## FALCON FIRE PROTECTION DISTRICT

Date: September 6, 2023

RE: Berisford 4 Lot Subdivision – Minor Subdivision

BERISFORD SUBDIVISION

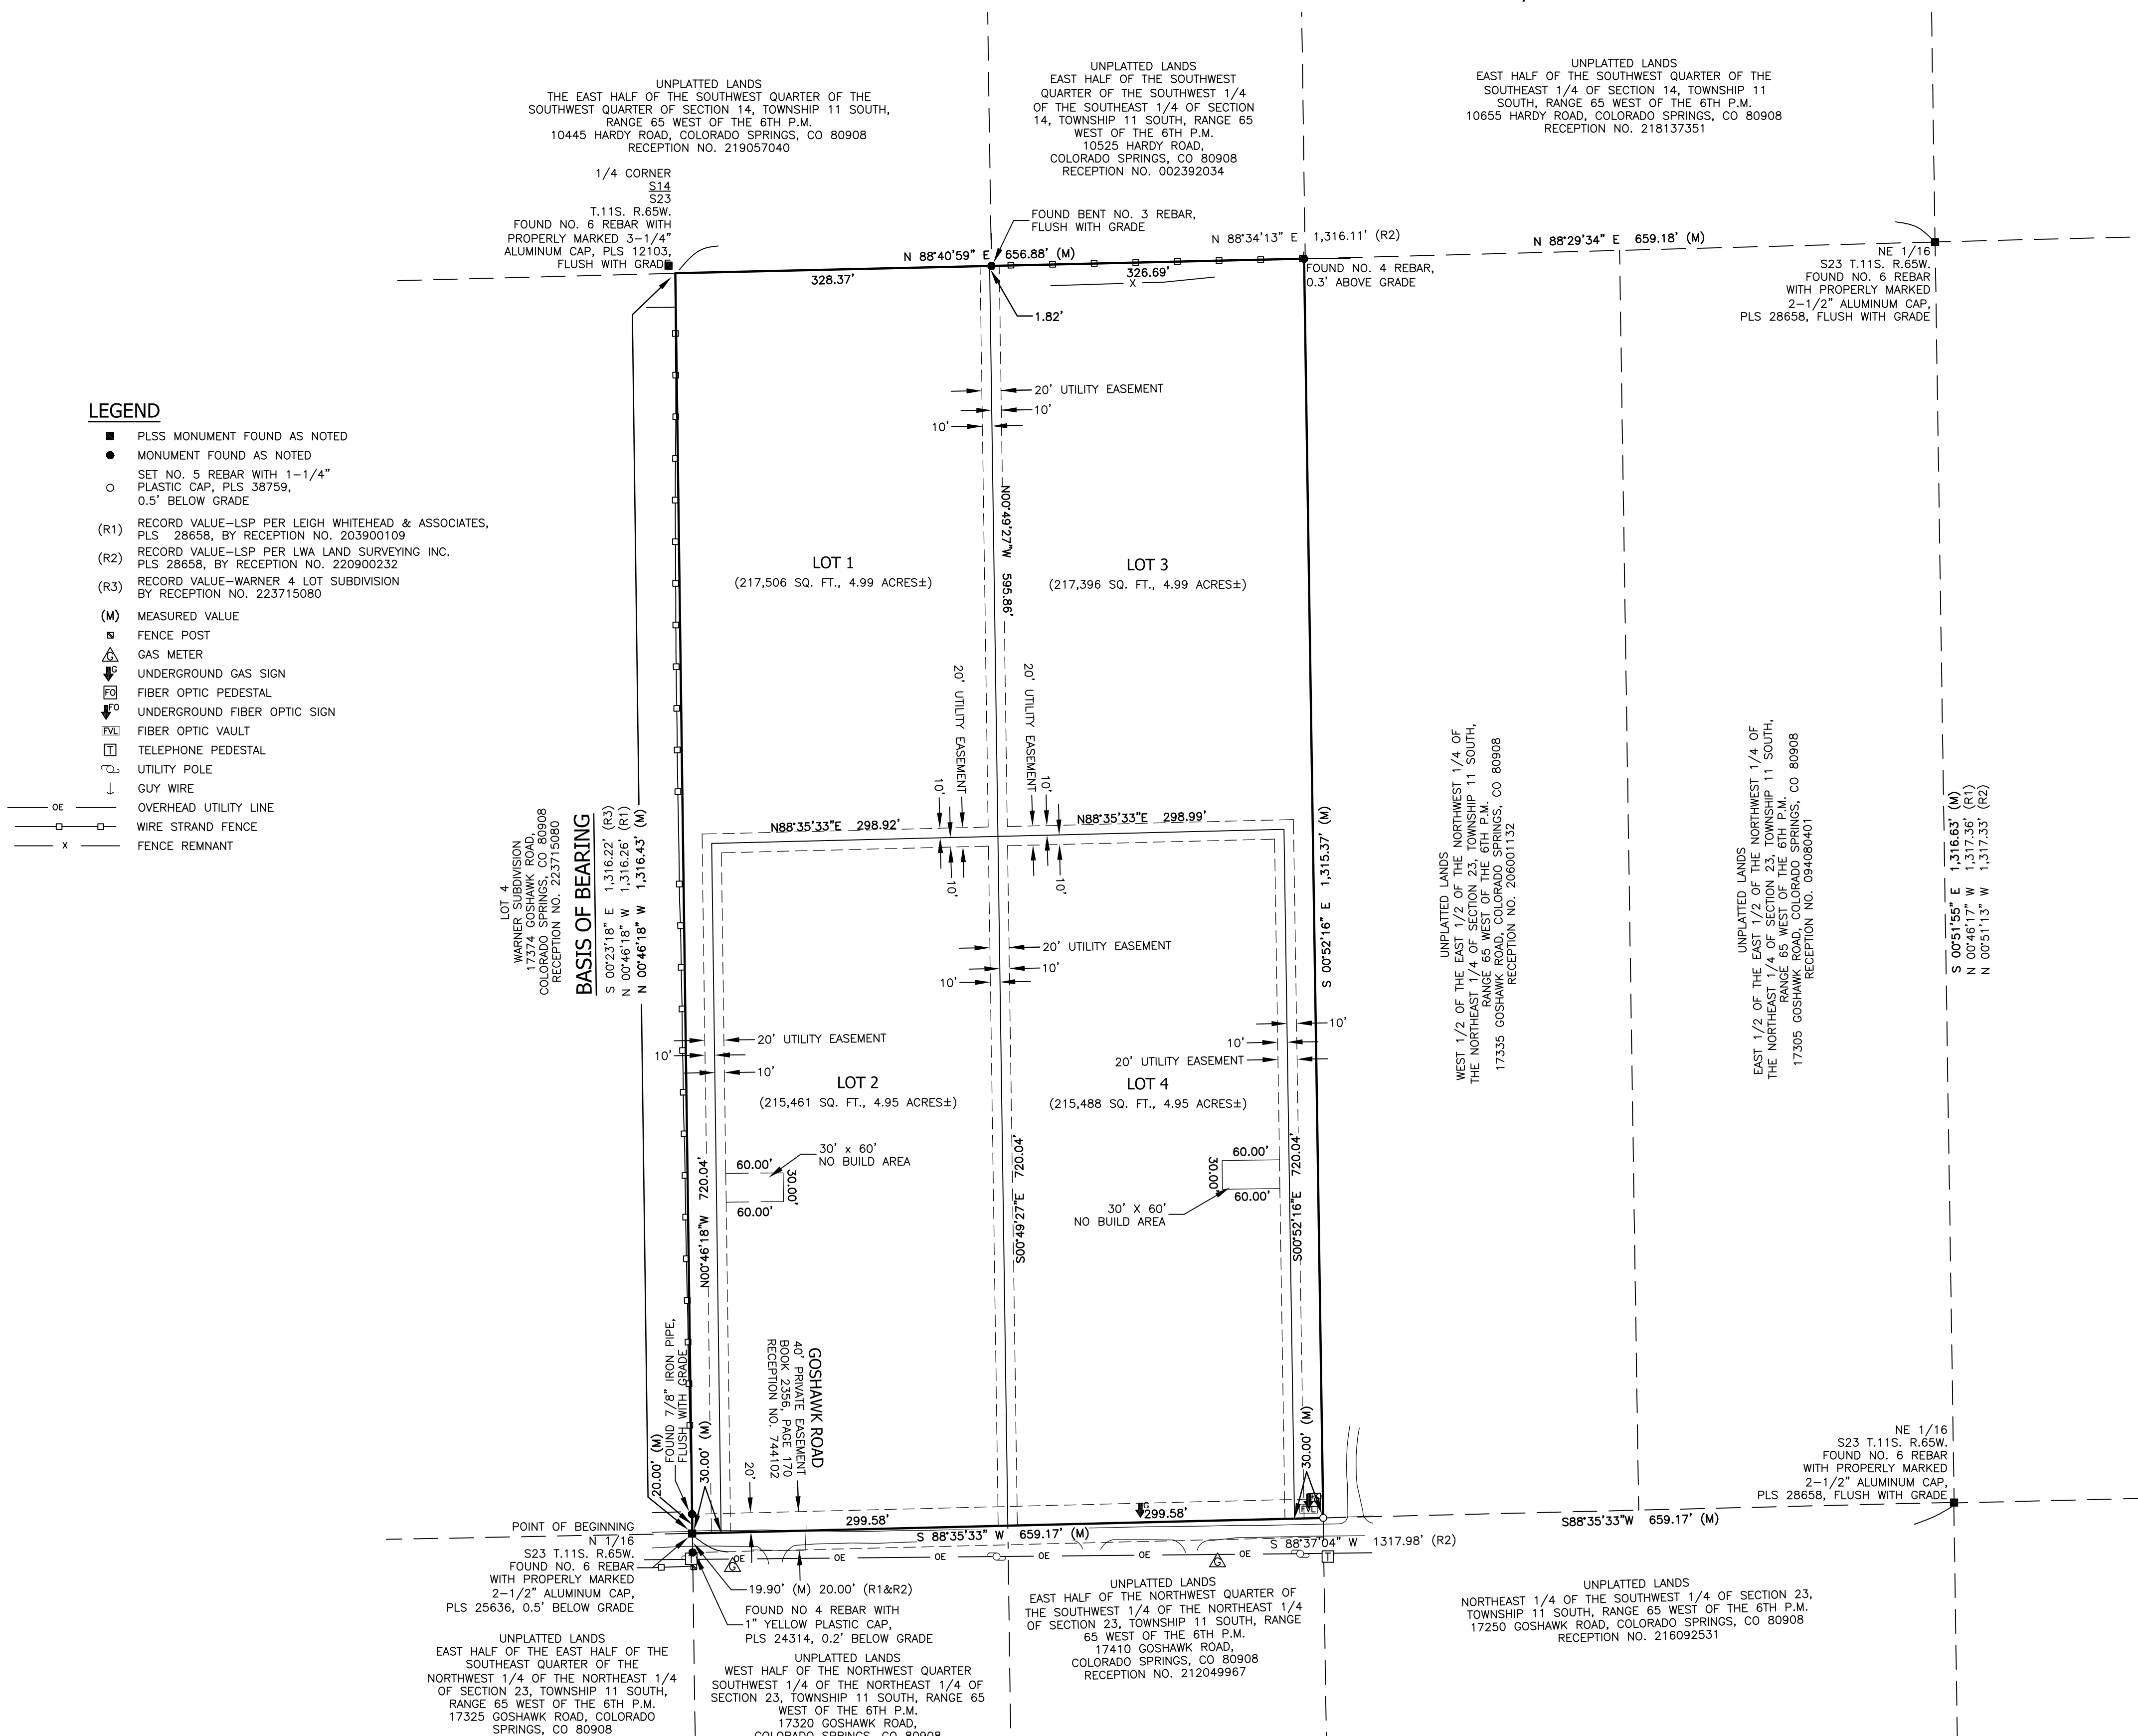
- 1) You will need to add a turn-a-around in the center of lots 2 & 4 for fire apparatus.  
This is due to the two-flag lot's (1 & 3) having a driveway greater than 150-feet in length per the fire code. Lots 1 & 3 shall also have a turn-a-around closer to where the homes are to be built in the future.
- 2) The driveways shall also be designed to support the weight of fire apparatus.
- 3) The four lots shall follow the FireWise program on tree mitigation ([firewise.org](http://firewise.org)).
- 4) Below you will find the applicable fire codes that need to be followed.
